Ref. No: 260-280 Edward Street
Contact: Cameron Collins

17 August 2018

Re: Wagga Wagga Rural Referral Hospital Redevelopment Stage 3
Your Ref: SSD 9033

Figure 3.2: Proposed reinstated car parking spaces under existing demountable building (south of CP3)

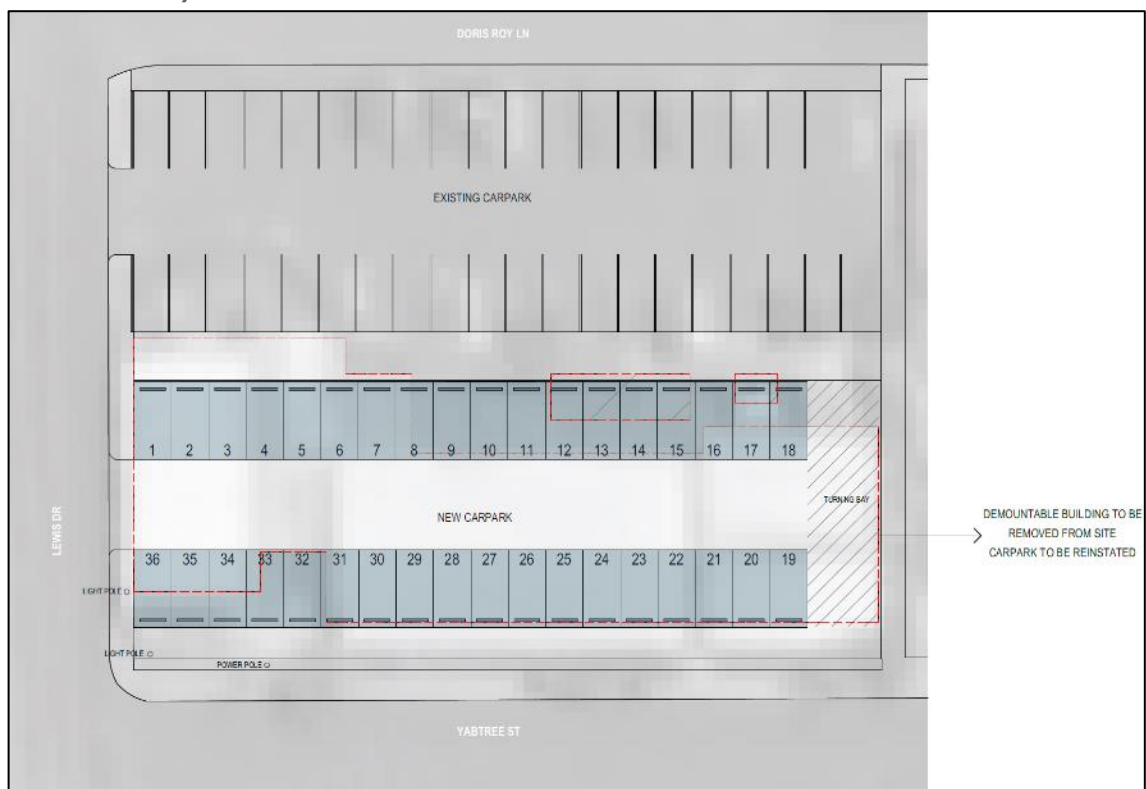
With respect to the statement regarding DCP compliance, the applicant's claim that the reinstatement of 36 existing spaces (under the demountable buildings) contribute to this compliance should be examined. These are spaces that were originally available to the hospital that were temporarily removed to allow for earlier stages of construction. It is unclear from information provided within the application as to whether these spaces were ever replaced elsewhere on site as part of the placement of the demountable buildings. If they were not, it is questioned as to whether they should be credited towards that required for the Stage 3 project.

Figure 3.5: Proposed on-grade car parking facility

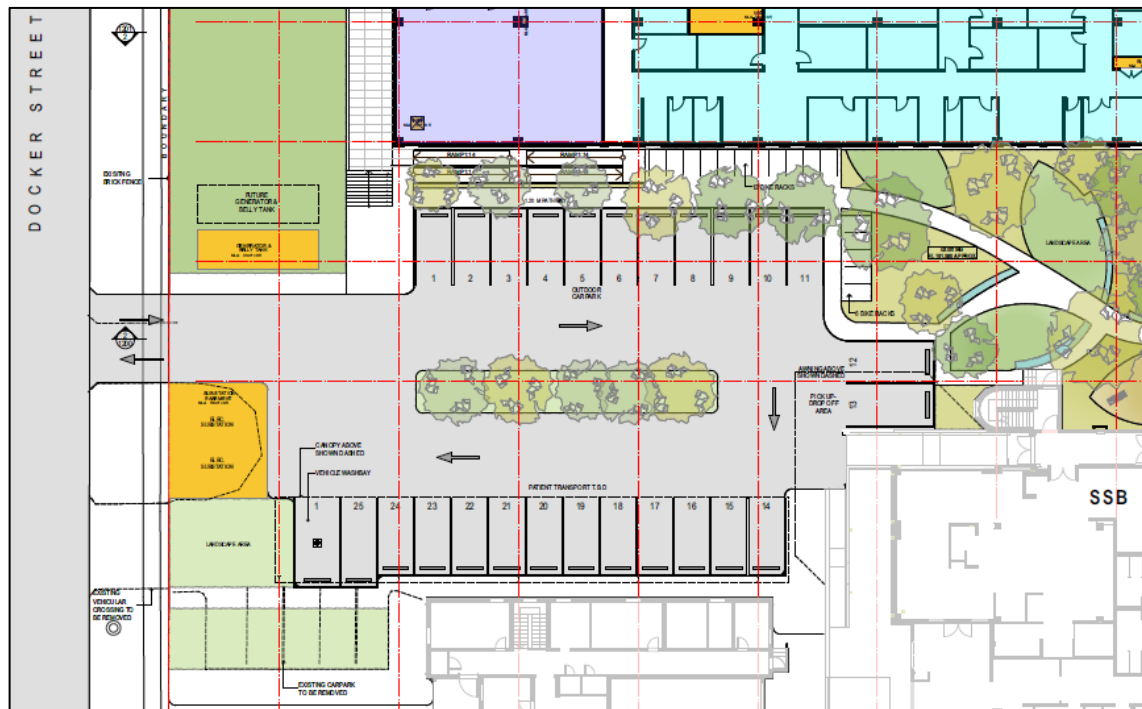
Further to this, a minor reconfiguration of the existing external carparking area along the northern elevation of the stage 3 building is proposed to accommodate the development and will yield an additional 9 carparking spaces. These works should also extend to the final elimination of the former decommissioned

driveway to Edward Street and its replacement with parking. This area could accommodate between 6 to 8 carparking spaces in addition to the 9 spaces proposed to be gained.

Consideration could be given to the redesign of this area by transferring the adjacent "patient transfer" carparking spaces into this area and relocating the open space adjacent to the northern side of the Harvey House building. The open space would have a far improved aspect with regards to solar access during winter months, would provide an improved presentation and setting for Harvey House to Docker Street and would potentially be more readily accessible from the Stage 3 building (whilst also remaining accessible to staff facilities in the SSB building).

**Figure 7.2: Edward Street/ Docker Street intersection upgrades (highlighted in blue) due to background traffic growth**

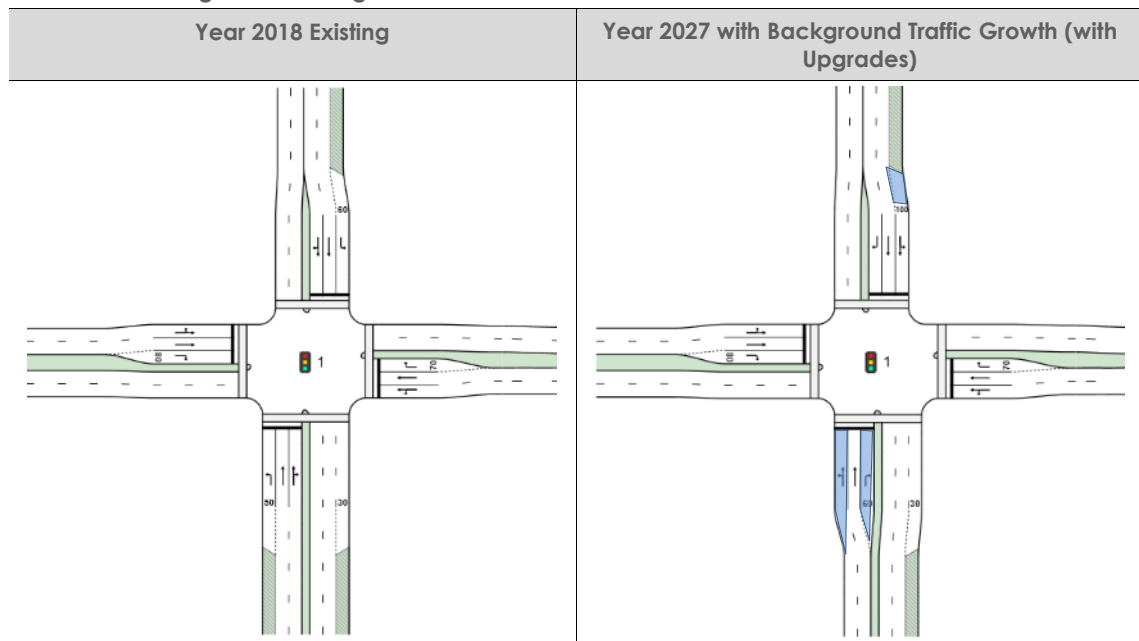
Of particular concern is the traffic impact requirements identified for stage 3 in Table E1 of the Traffic Impact Assessment (TIA). Upgrades to the Edward Street intersections at Docker Street, Murray Street and Brookong Avenue will have wider implications impacting on the local road network which have not been considered within the TIA. Council would object to any determination that may require these works if they have not been the subject of detailed consultation with both Council and RMS.

Council notes the proponents conclusion that general traffic growth will instigate the need for the intersection upgrades by Council/RMS irrespective of any impact generated by the Stage 3 development. This assessment fails to consider the cumulative impact of the overall hospital development and its contribution to the baseline traffic volumes/conditions contributing to this issue. It is not reasonable to conclude that the community should be fully responsible for future required upgrades without having regard to the overall impacts of the hospital operation.
